# INTER-OFFICE MEMO

DATE: September 11, 2023

FROM: Megan Jones, MCRP - Senior Planner

RE: Project #2023-008767/SI-2023-001056  
Site Plan-EPC Major Amendment, 200 Tramway Blvd. SE

PROJECT TITLE: **STARBUCKS - TRAMWAY**
200 TRAMWAY BLVD. NE
ALBUQUERQUE, NEW MEXICO 87123
JOB NO.: **SF-TRAMWAY**
PROJECT MANAGER: **DEVIN NGUYEN**
DRAWN BY: **DIN**
DATE: **25 Jun 2023**
SCALE: **AS NOTED**
SHEET TITLE: **SITE PLAN**
SHEET NO.: **AS101**

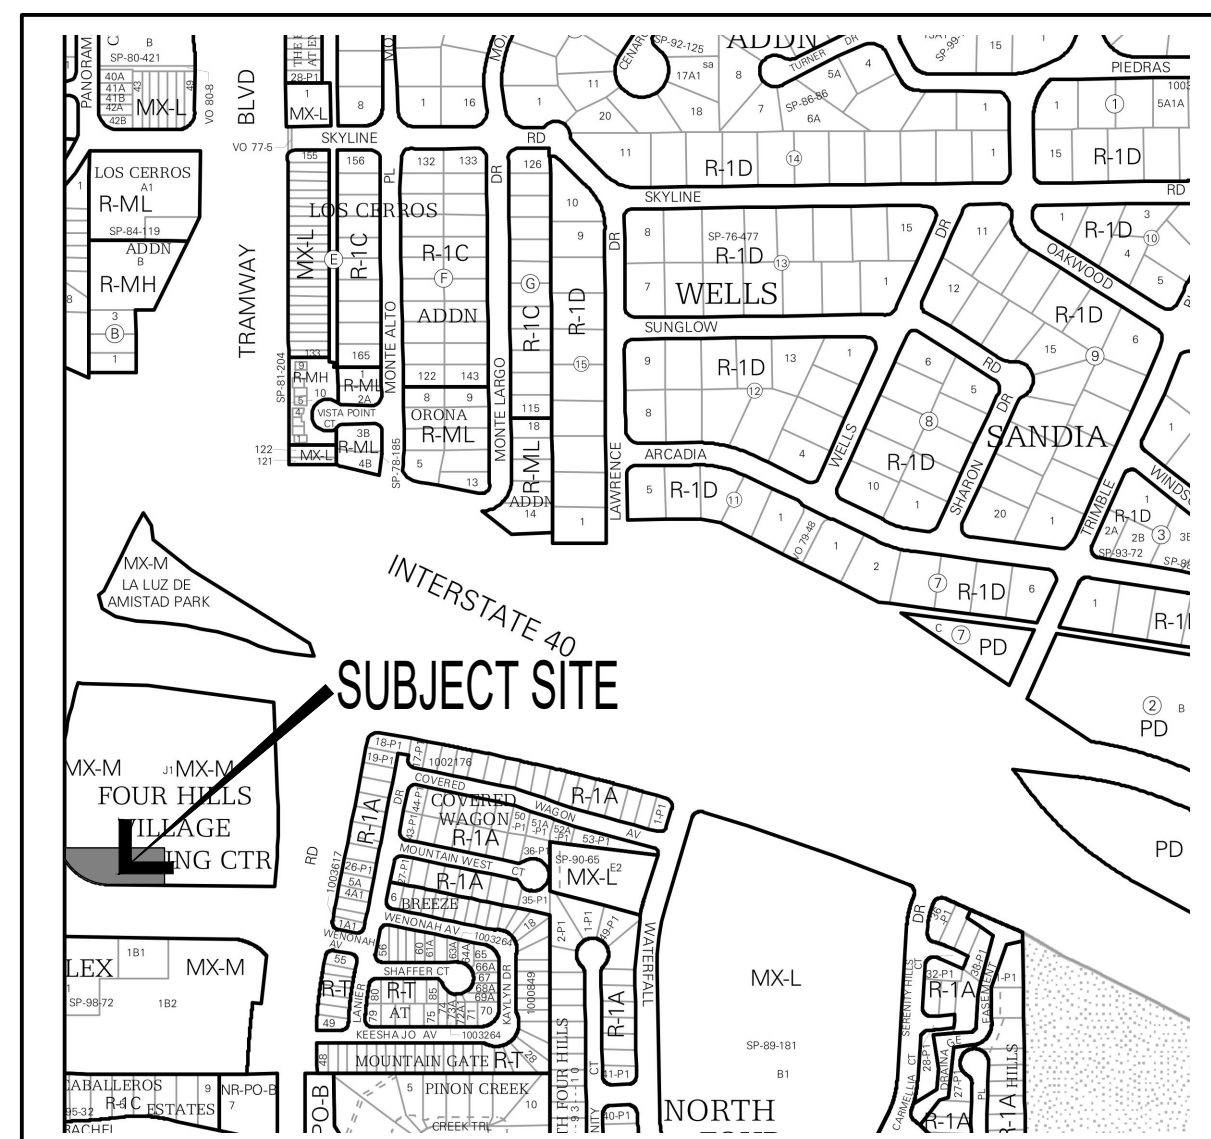
1. AS-101 Site Plan Sheet:
  - a. Keyed notes 17-21 have been added to reflect Conditions 5b & 5c.
  - b. General note E
2. New Grading and drainage sheet C3.
3. The master Utility Plan Sheet was renamed from sheet MU-1 to sheet C4.
  - a. General note 12 and keyed note 14 are new.

NOTE: The EPC approved the requested amendments on 7-20-2023.

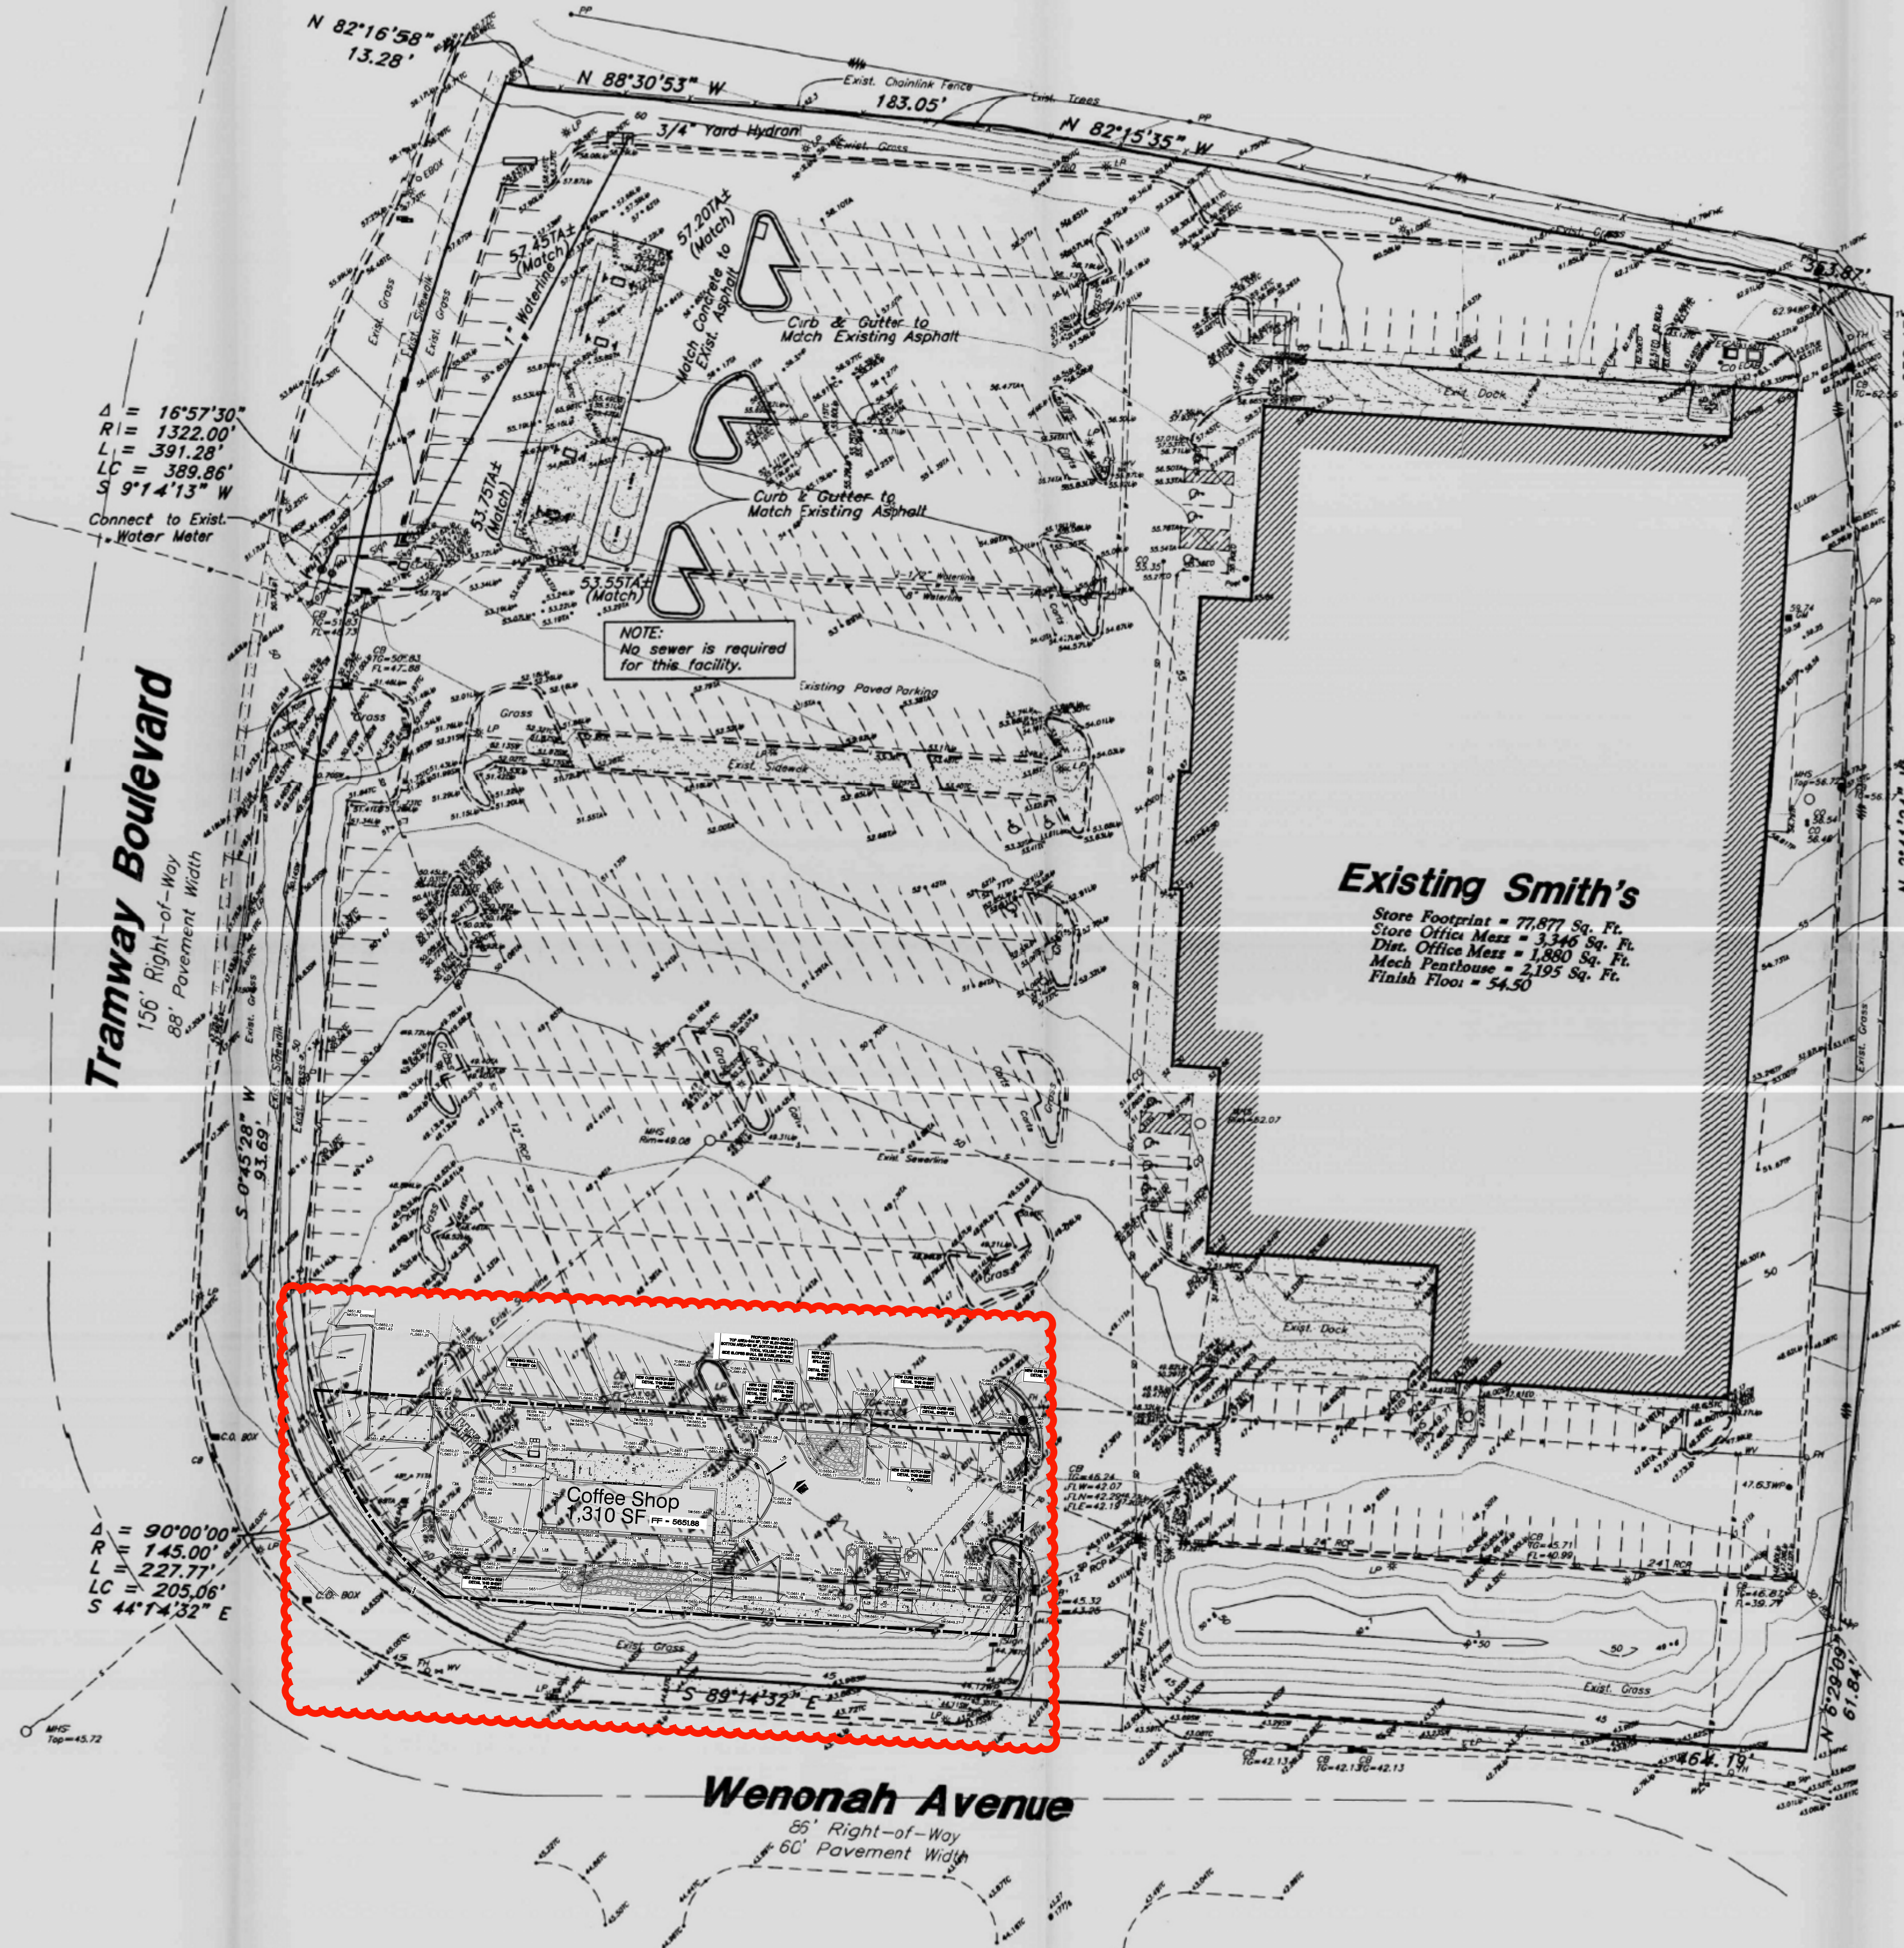
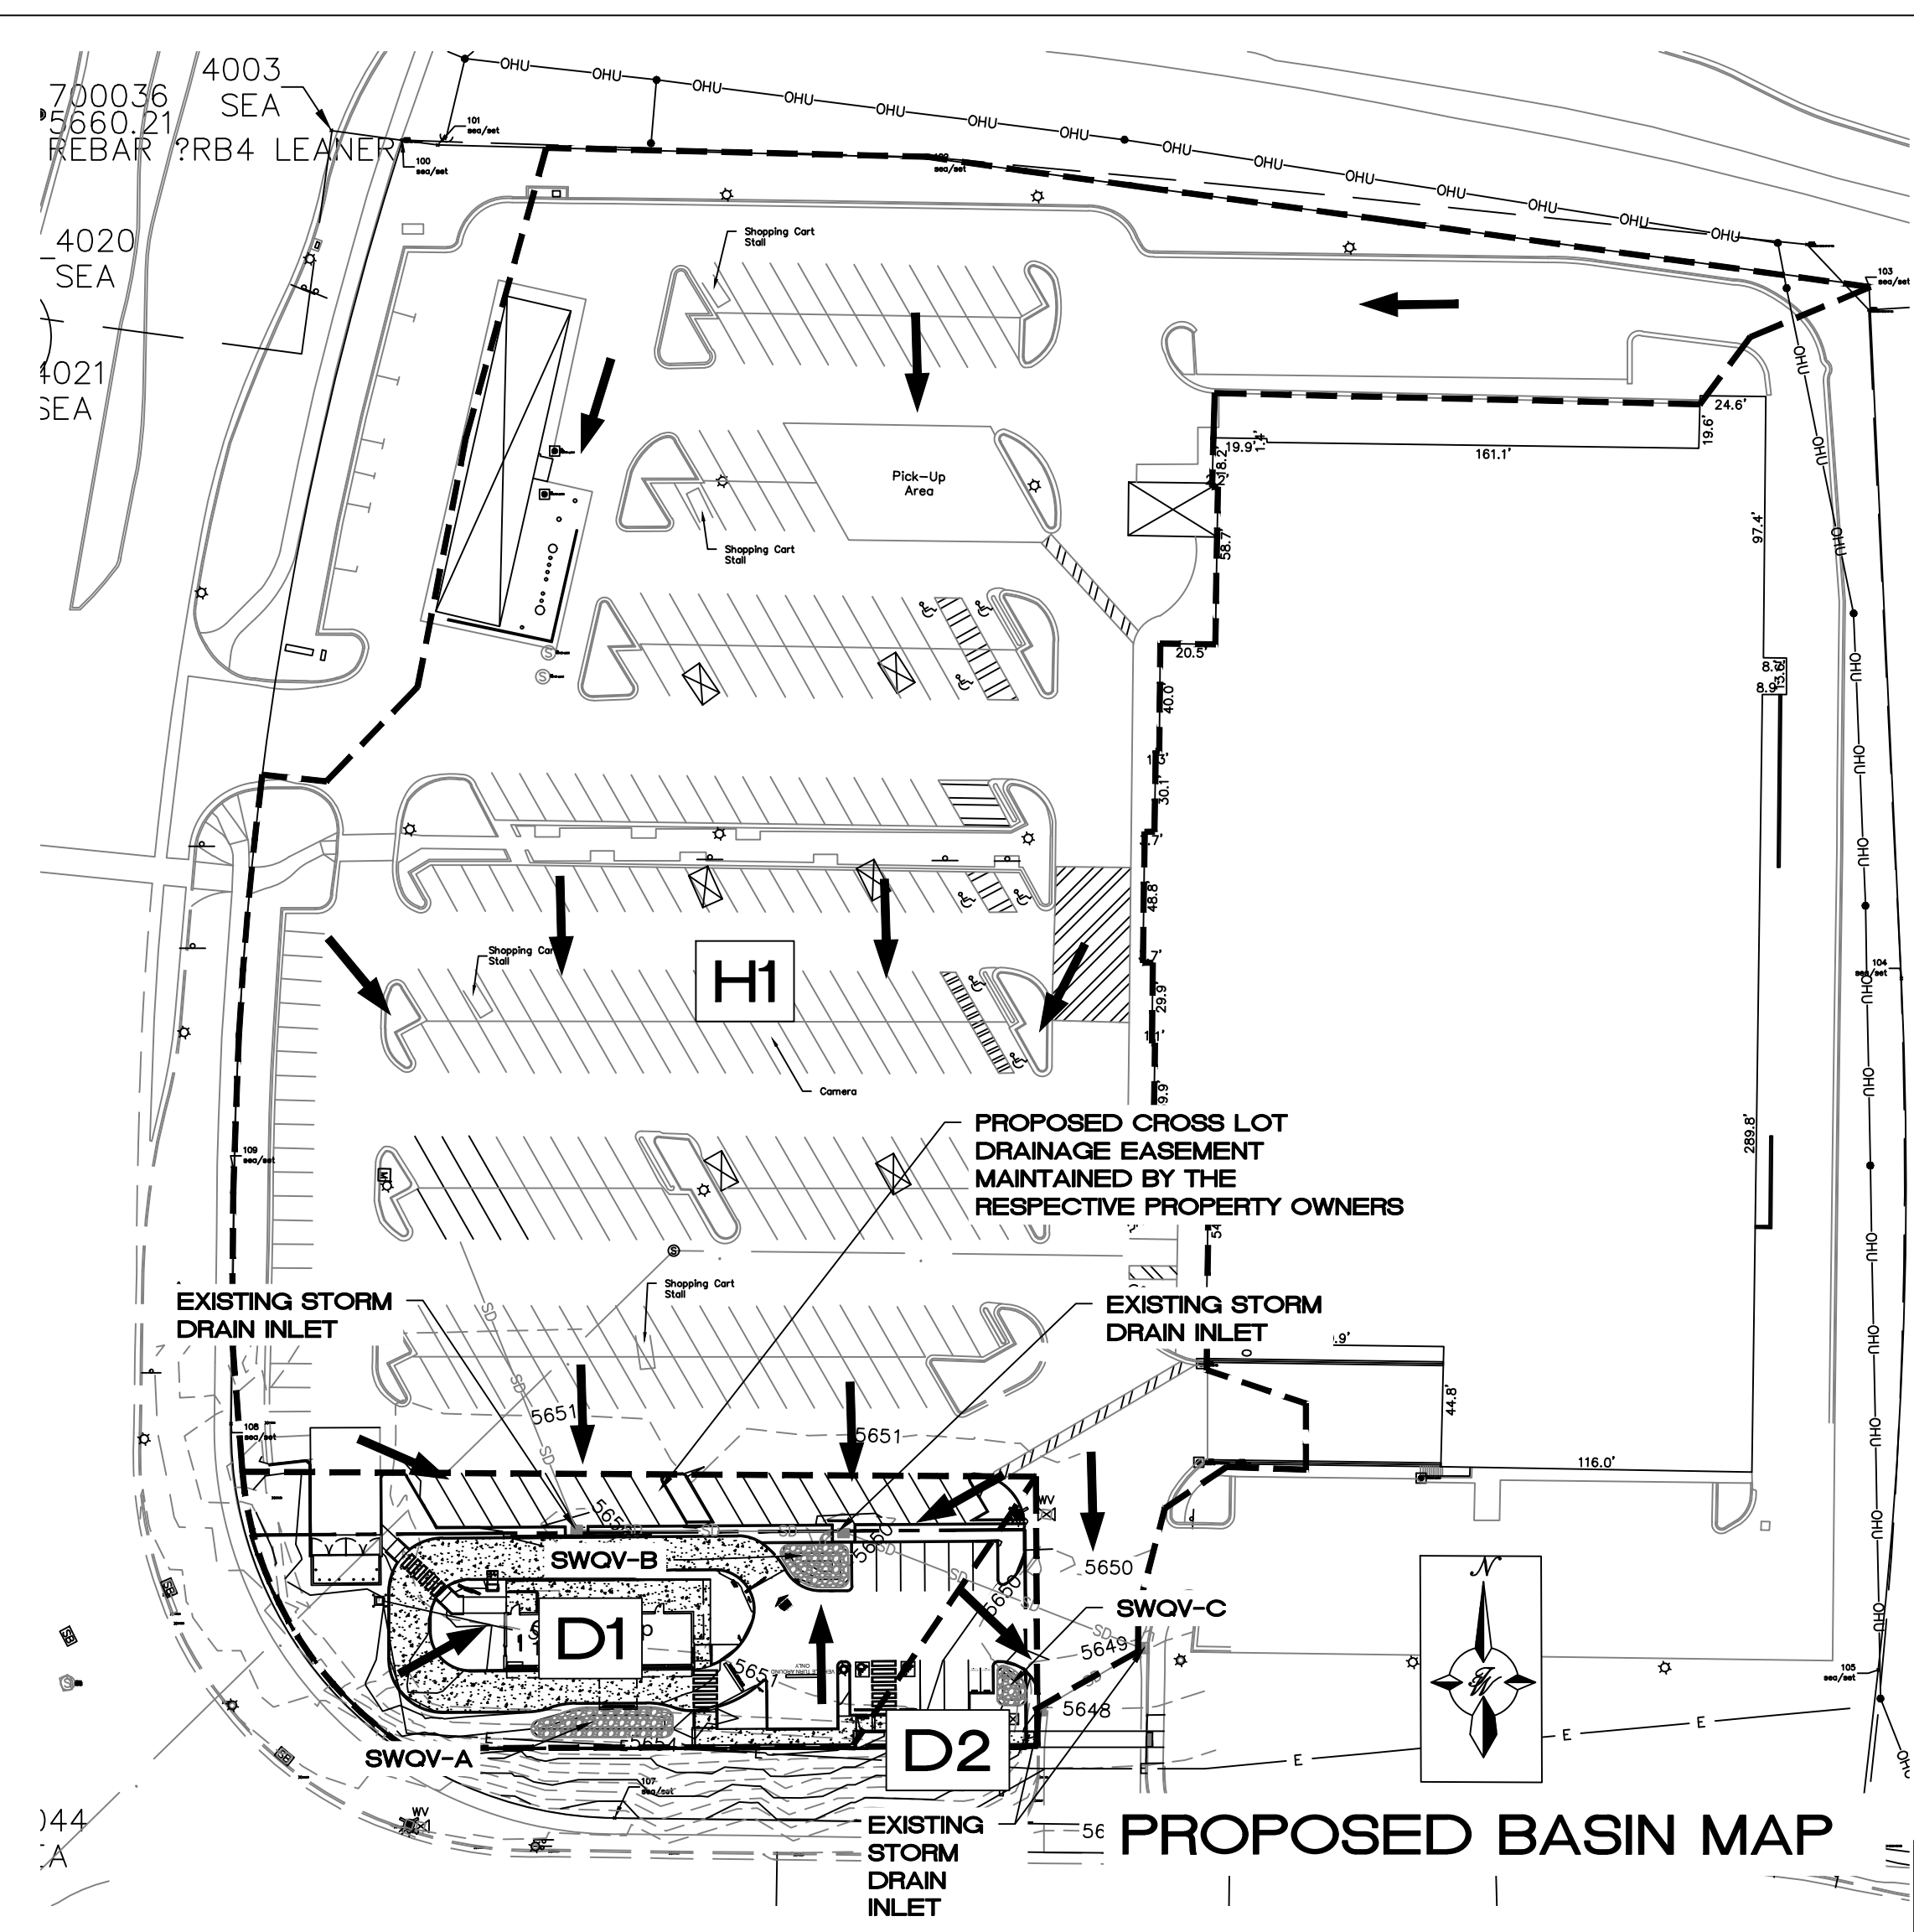
- a. A note shall be added to sheet C1 stating that the EPC approved the requested amendments on 7-20-2023.
  - b. The G&D Plans show exiting and proposed G& D as sheet C3.
3. Condition 4, a: The applicant shall update the Major Amendment sheet to reflect the provided bicycle spaces. This was only included on the Site Plan sheet associated with the request. All amendments shall be reflected on the Major Amendment Sheet.
4. Condition 4, b, 5-11: Satisfied.
5. Condition 12: The applicant shall provide a note on the Site Plan and light pole detail stating that all building surface mount light fixtured will be shielded and downward focused.
6. Condition 13: Satisfied.
